# COUNTY COUNCIL'S RESPONSE TO CONSULTATION ON THE FOLLOWING DEVELOPMENT PROPOSAL

**Application No:** 19/00963/OUT-2

**Proposal:** Re-submission of application 17/02394/OUT - Outline planning permission for up to 40 dwellings with associated landscaping, open space and vehicular access off Berry Hill Road.

**Location:** East Of Last House Adjoining And North Of Berry Hill Road, Adderbury

SITE ACCESS JUNCTION @ 1:1250 SCALE

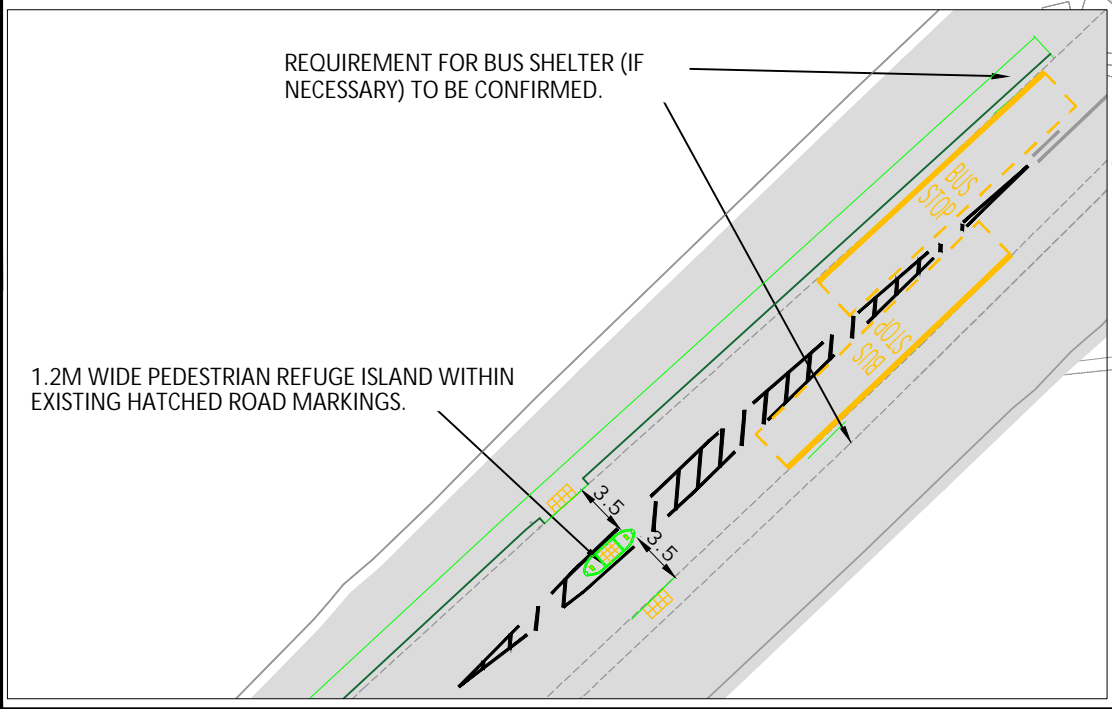
The primary vehicular and pedestrian access is proposed to be taken via an existing access off Berry Hill Road. This access is located within a section of Berry Hill Road that is subject to national speed limit. Para 2.6.2 of the Transport Statement (TS) suggests that the 30mph speed limit shall be extended to cover the entirety of Berry Hill Road right up to the junction with the A4260 Oxford Road.

The application proposes to implement a new footway along the northern side of Berry Hill Road to provide a direct pedestrian link between the site and the remainder of the village of Adderbury (up to Horn Hill Road). This link will clearly be of benefit to residents of the existing properties along Berry Hill Road in reaching the village centre safely and directly. In addition to that, a new crossing point within a pedestrian refuge with associated dropped kerbs and tactile paving along the A4260 Oxford Road shall be provided. These improvements are welcomed.

In the context of an outline application, all access arrangements need to be agreed at this stage. Besides the primary point of access, I am rather concerned by the lack of pedestrian access onto Berry Hill Road from the western part of the development.

I feel that the application has not taken advantage of its frontage to Berry Hill Road to enhance site permeability by providing a pedestrian connection which would be a direct and shorter path into the existing village. See below.

Without this provision, residents and visitors would have to walk back over 300m through the primary site access and the spine road a distance that should take a few metres from most dwellings. Application is strongly recommended to include this link. **(To be conditioned)**
